Our Ref: R/2022/15/A
File No: 2023/021407
Your Ref: SSD-33258337

Response to Submissions – Toga Central – SSD-33258337

Thank you for your correspondence dated 10 January 2023 inviting the City of Sydney (the City) to comment on the Response to Submissions (RtS) submitted for the Toga Central development at 2-8A Lee Street, Haymarket.

Upper Link RL21

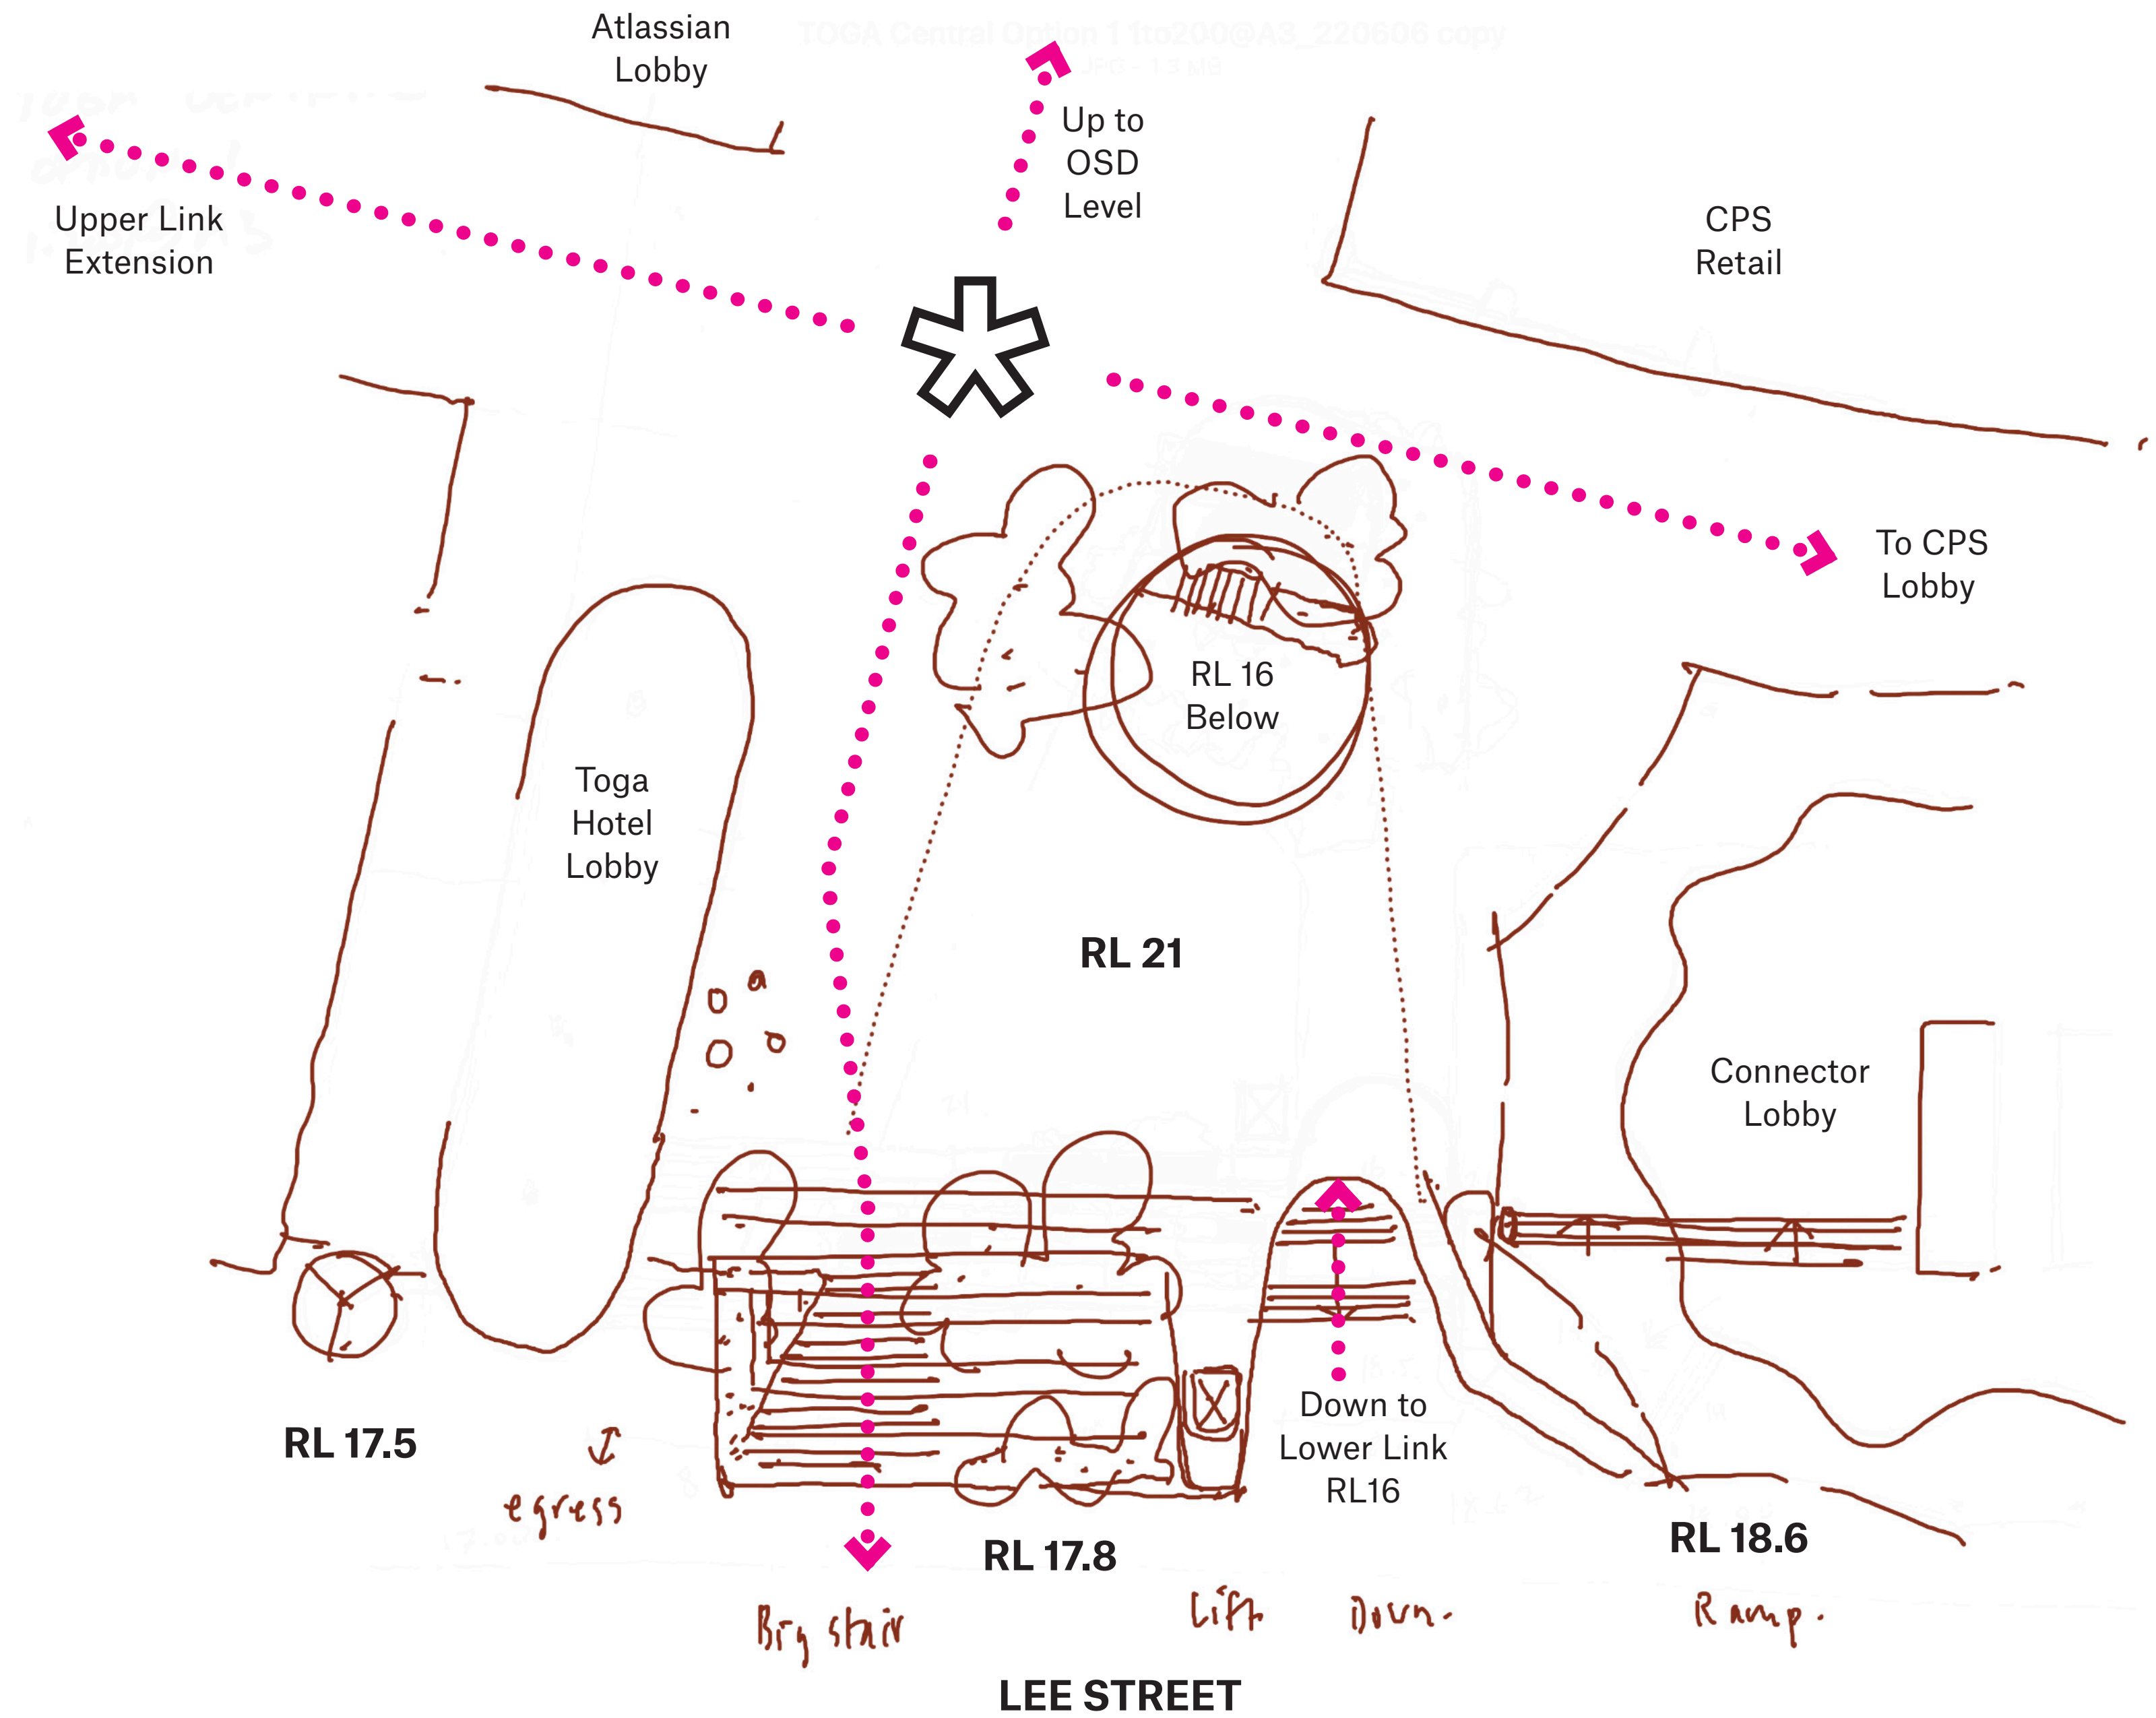
In addition, it is important that the two oculus that provide light to the below ground concourse area (one on Toga land and one on Central Place land) be aligned geometrically with the primary structural arrangement to appear coordinated between the two applications.

Lower Link RL16

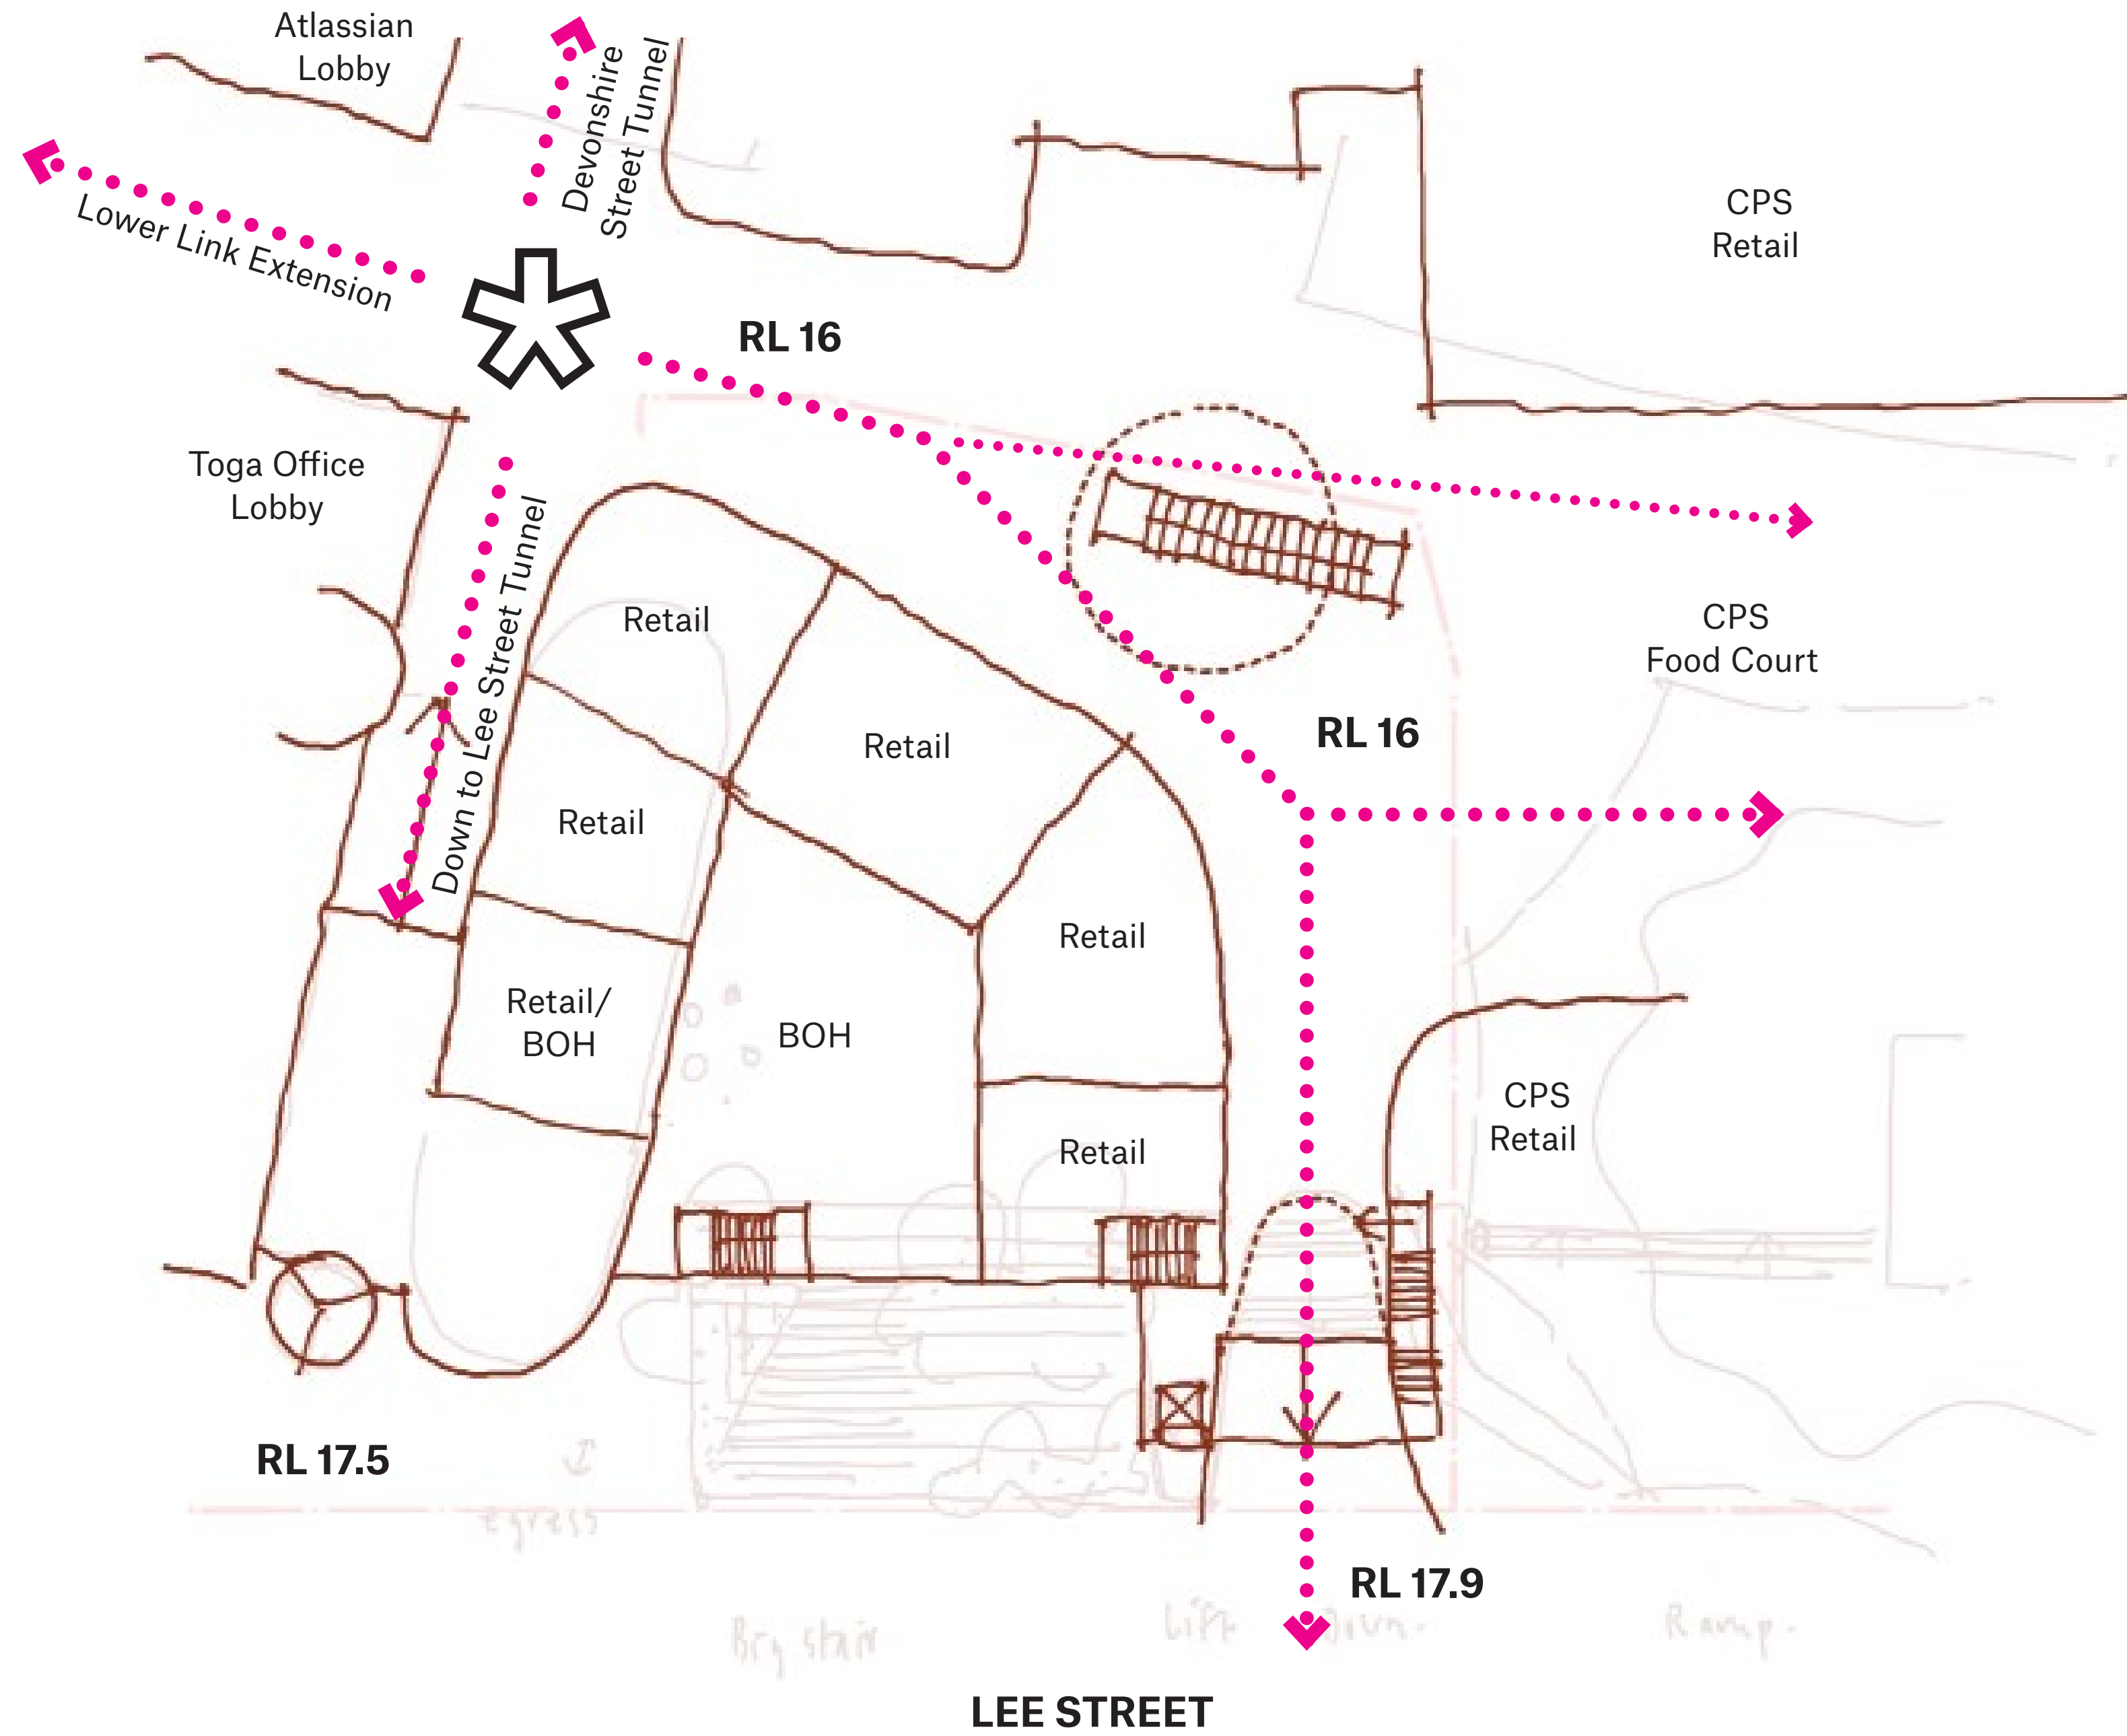
Given the importance that has been given in the proposal to the east-west connection between Lee Street and the over station development as a key people movement corridor (see Figure 1), the City recommended that allowance for a ramp on the Lee Street frontage be provided within the Toga site.

The plans have been amended to include a publicly accessible lift next to the Lee Street stairs, however a ramp within the Toga development on plans reviewed by the City has not been provided. The RtS states that ramp access is provided within the Central Place Sydney development.

The amended architectural plans do not show where this ramp is located. If the ramp described in the RtS is located on the southern side of the Connector building at Central Place Sydney, this is not considered to provide equitable, dignified access within the identified east-west pedestrian movement corridor, which is not acceptable.

Alternatively, if this ramp is located on the northern side of the Connector building, this is not identified in any of the plans reviewed by the City.

The reliance of a lift in this key east-west movement corridor at the Lee Street stairs is not supported by the City. A ramp must be provided on the northern side of the Connector building (in consultation with Central Place Sydney if required) and this must be resolved prior to determination. Therefore, all of our comments in Part 2.1 of our previous advice remain relevant.

- The City recommended that the extent of the BoH at RL 16 from the Lee Street entry should be reduced to elongate the stairs further east and to allow inclusion of a ramp. In response, the extent of the BoH has been reduced by a very small amount to allow the proposal to comply with DDA requirements. However, no ramp has been provided. The change has not positively impacted the layout or generosity of the stairs and the design remains unsupported from an urban design perspective.

- No changes have been made to the hard vertical edges. The impact of the vertical walls could be lessened through introducing stepped planters so that vertical walls are no more than 1m in height.

- The City reiterates that the visual aperture from Lee Street up to the plaza should be increased through the removal of vertical walls. This has not been addressed.
